City of Mercer Island
 Building Department
 c/o Don Cole,
 RE permit 2011-147 – Clarkson Residence 8163 W Mercer Way

This letter is in response to your email sent 5/1/24. We have been in contact with both Brett Mozden and Marc McGinnis about the as built condition and how it differs from the permitted drawings.

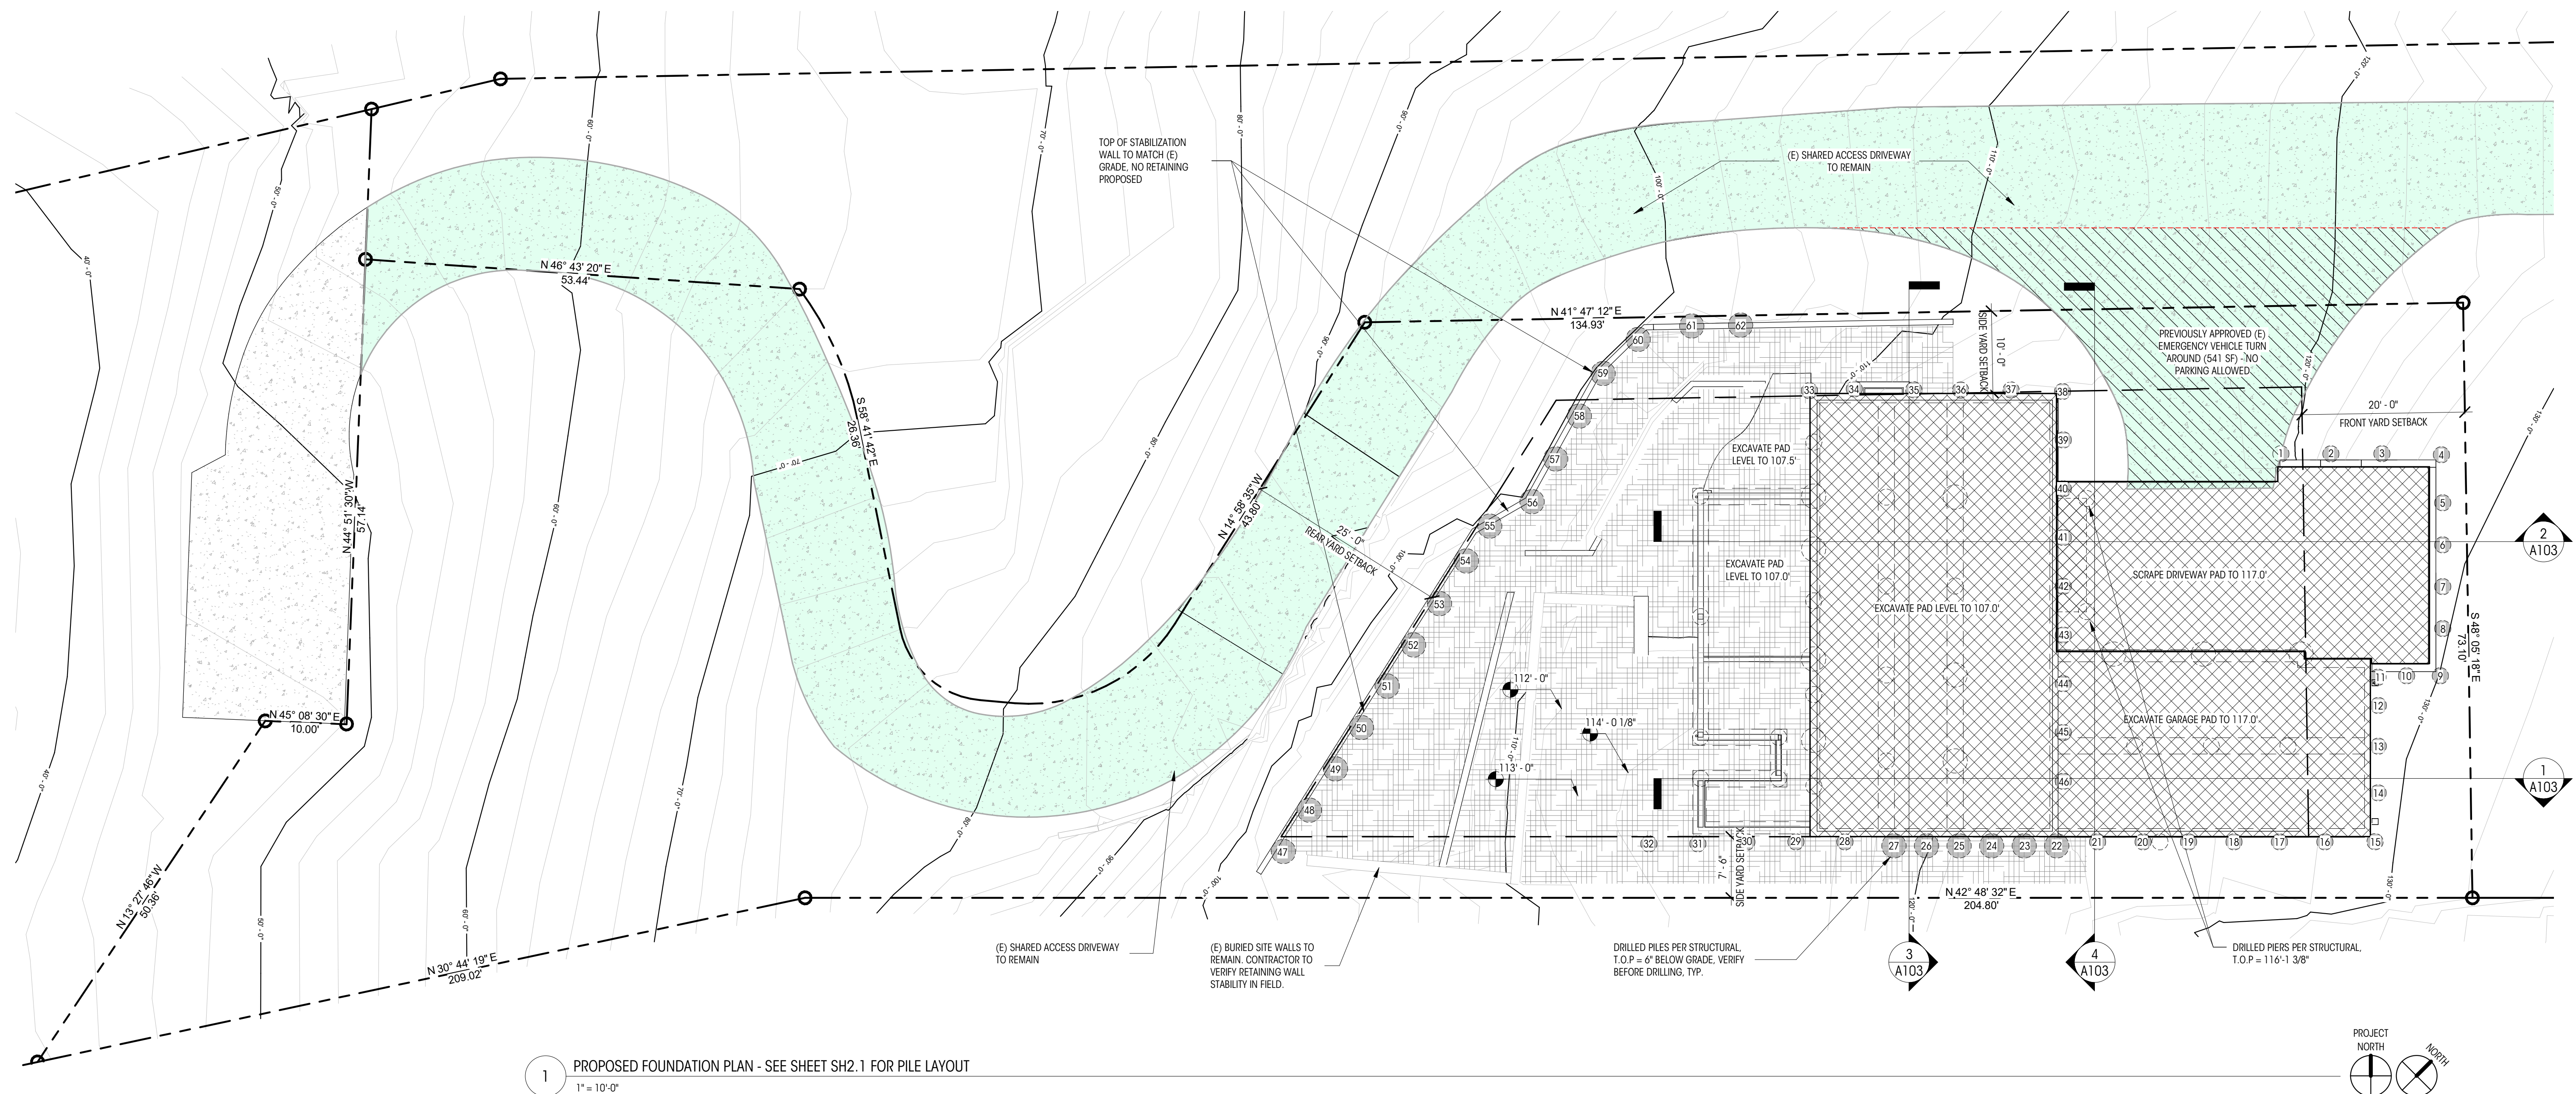
- *Clarify protection of the wall edge (guardrail, planters, etc.).*
 - **We have added a guardrail as the drop at certain points of the stabilization wall is now greater than 30". **

EXCAVATION PLAN

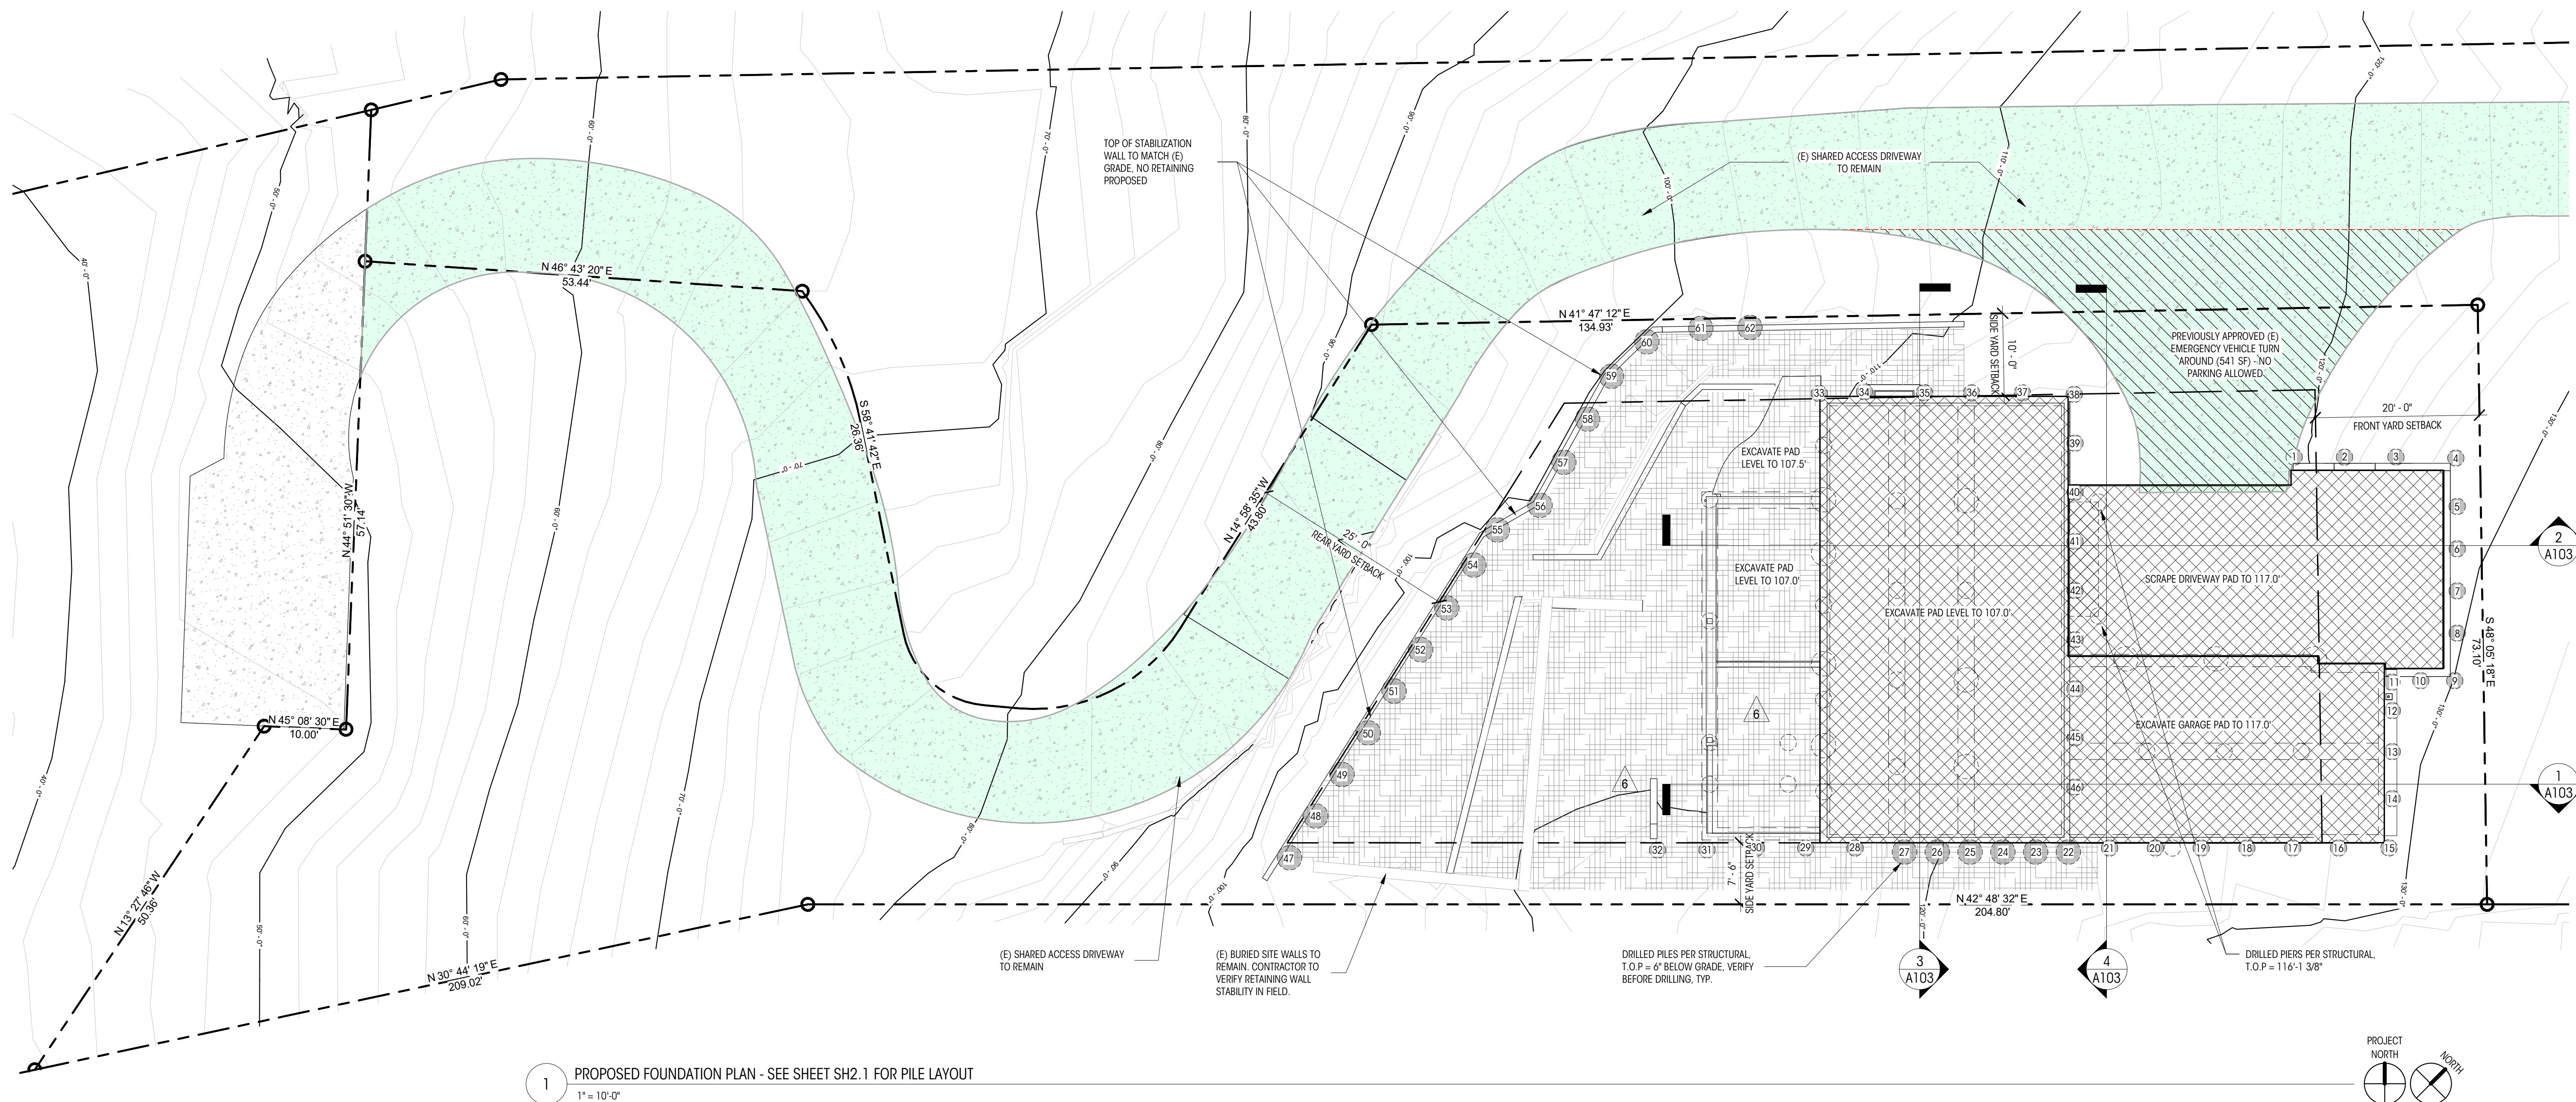
The soil stabilization wall was installed based on the permitted plans, however there was grading done at the top of the slope to provide access to equipment as the piles were driven. The area where the wall was installed was cut down to from an approximate elevation of 101.0' to an approximate elevation of 96.0'. As such, lagging was added so that the excavated portion of the site could be rebuilt on the east side of the stabilization wall. The western side of the wall was not rebuilt as the wall was designed to allow for a 16' vertical cantilever as shown in detail 10/SH3.1 in the approved permit set.

We have included an updated excavation plan (sheet A102) showing the lower grade on the western side. Additionally, we have included sections through 2 points on the wall to show that the passive pressure is met despite the road being below the noted passive pressure elevation of 89.0'. We spoke with Marc and utilized a 3h:1v slope when calculating the passive pressure diagrams.

- *Provide revised site plan with revised calculations for lot coverage, hardscape, etc.*
 - **No changes to the approved site plan as it relates to the extent of the stabilization wall, lot coverage or hardscape. The only change is the level of excavation/grading on the western side of the stabilization wall, those changes have been addressed in updated excavation plan A102.**
